Ribble Valley Borough Council  
Council Offices, Church Walk  
Clitheroe  
BB7 2RA

**Your ref:** 3/2021/0397  
**Our ref:** DC/21/2022  
**Date:** 07-JUN-21

**Location:** Land at Barrow Brook Enterprise Park Barrow BB7 9QZ  
**Proposal:** Proposed new light industrial units/retail trade counter

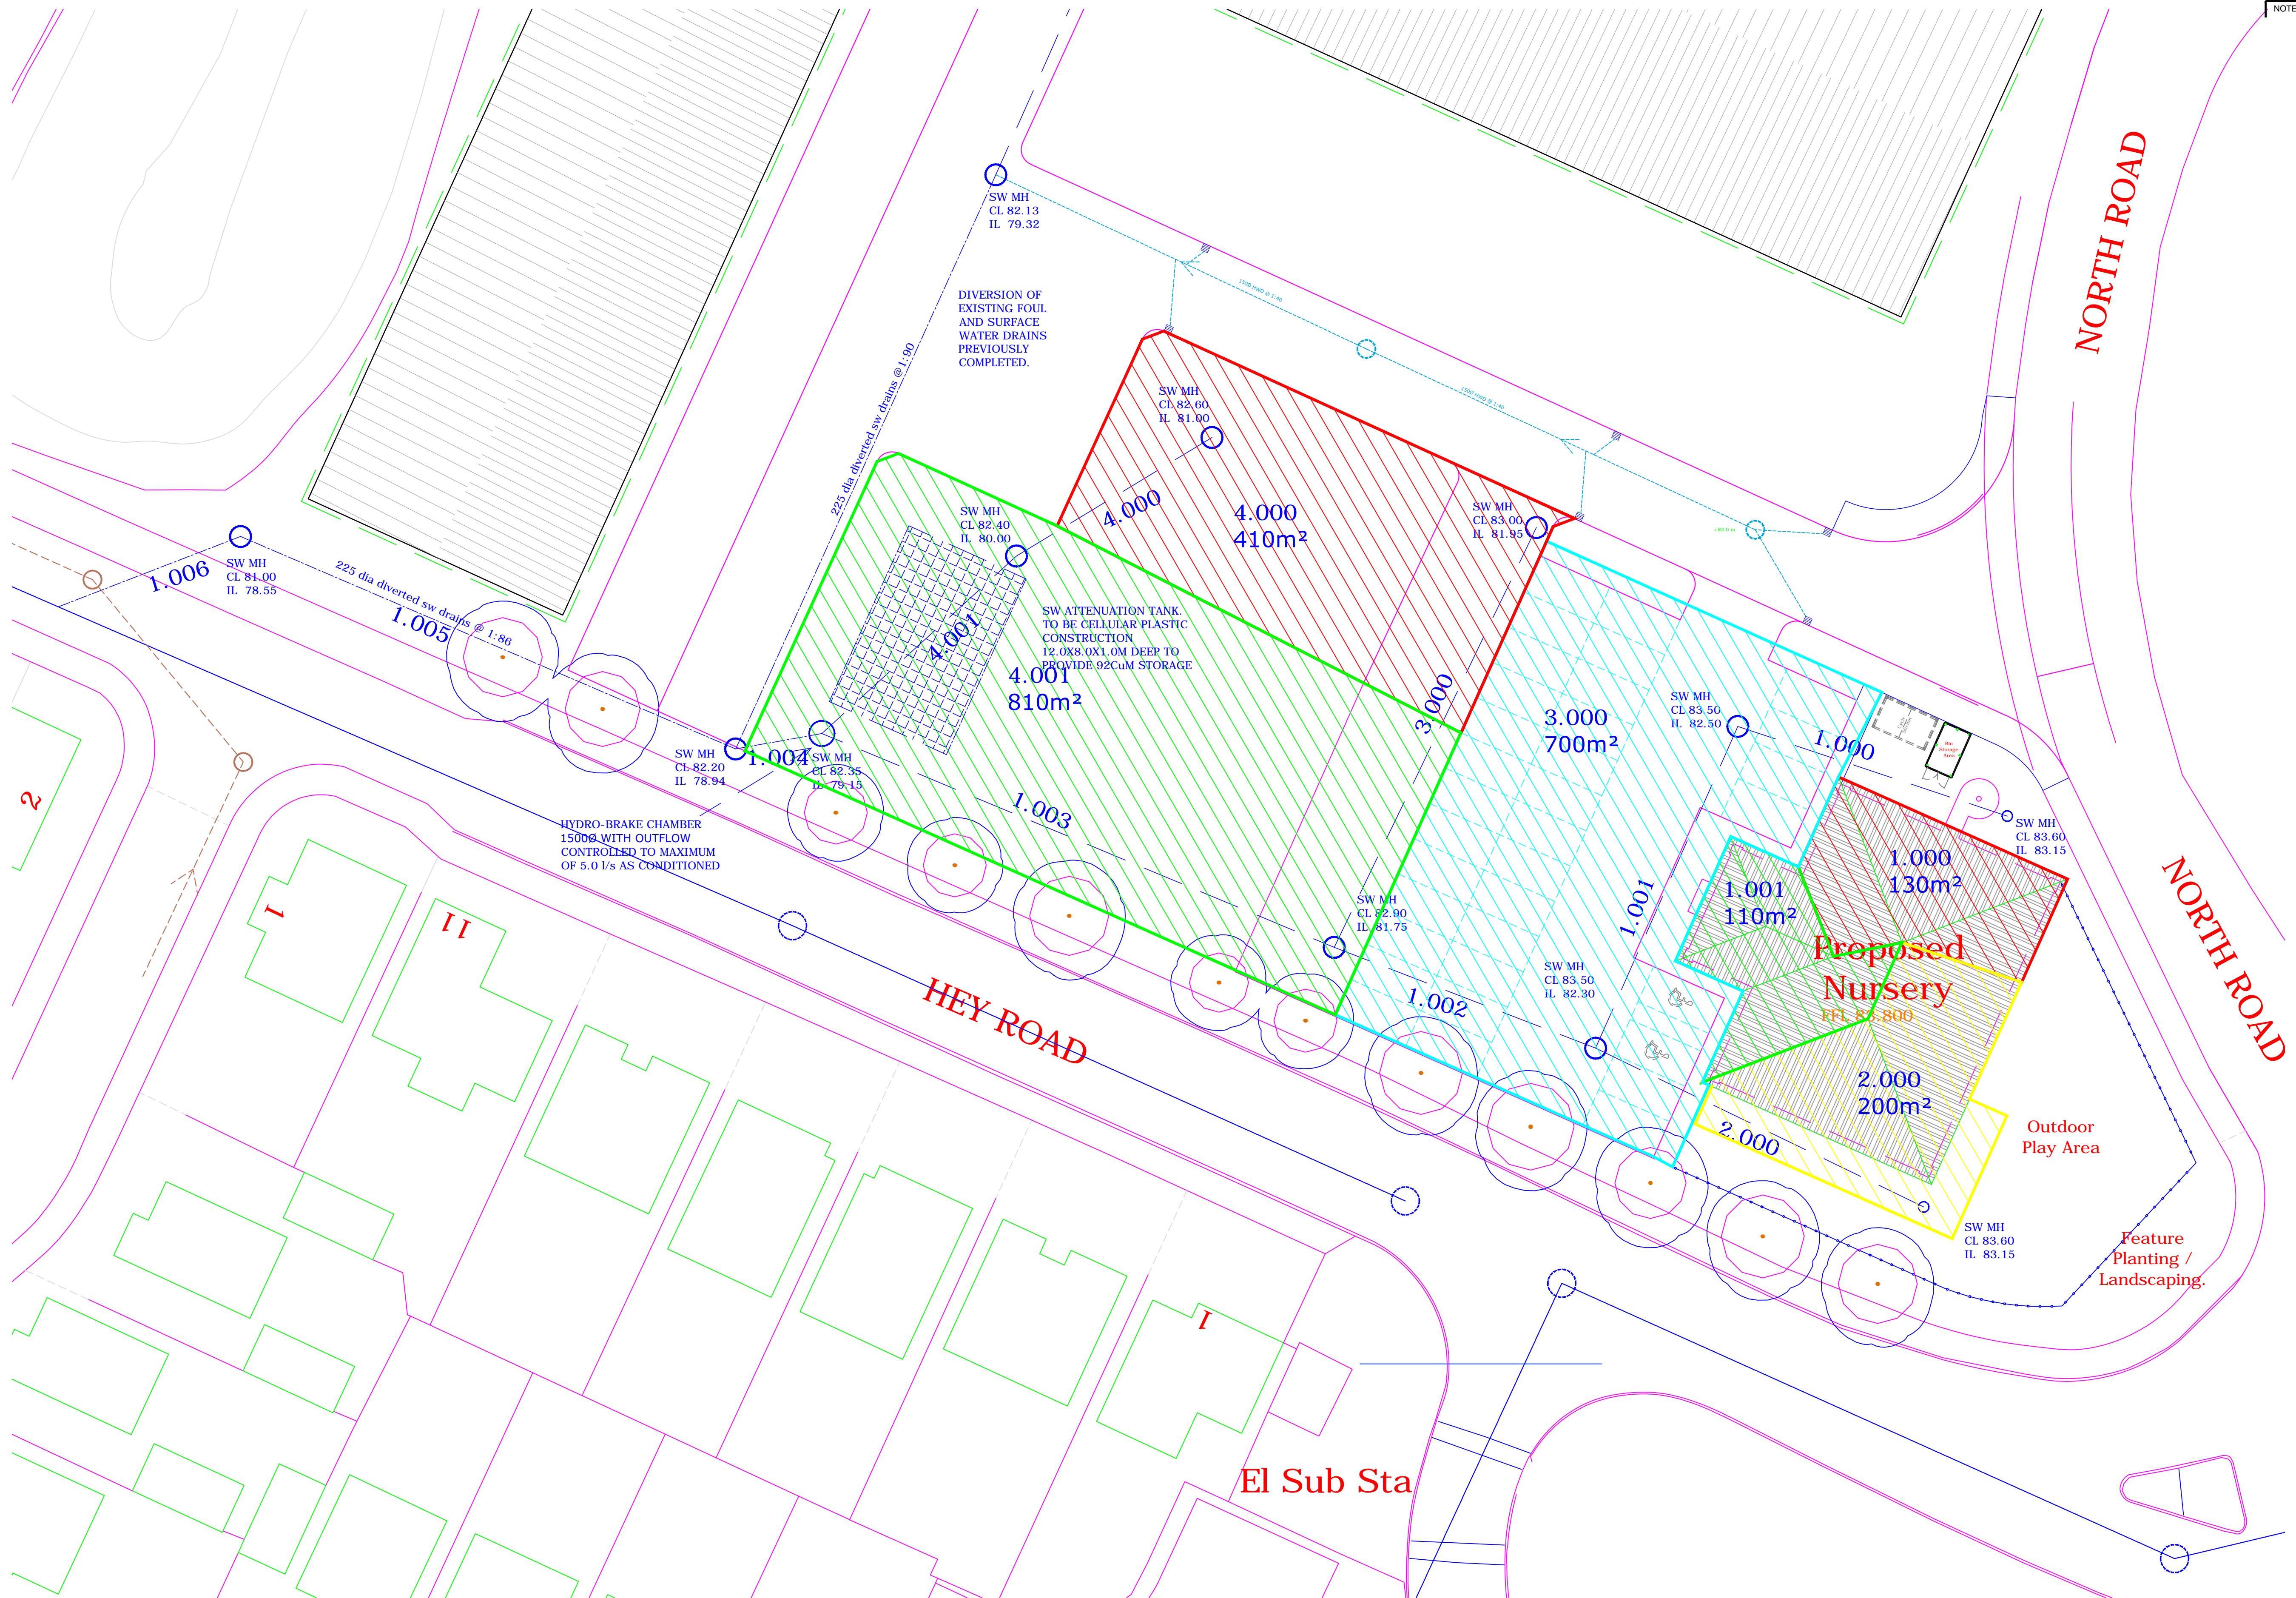
***Following our review of the submitted Drainage Strategy, we can confirm the proposals are acceptable in principle to United Utilities and therefore should planning permission be granted we request the following condition is attached to any subsequent Decision Notice:***

***The drainage for the development hereby approved, shall be carried out in accordance with principles set out in the submitted Proposed Site Drainage, Rev -, Dated - which was prepared by Partington & Associates Limited. For the avoidance of doubt and unless otherwise agreed in writing by the Local Planning Authority, surface water must drain at the restricted rate of 5 l/s. No surface water will be permitted to drain directly or indirectly into the public sewer. The development shall be completed in accordance with the approved details.***
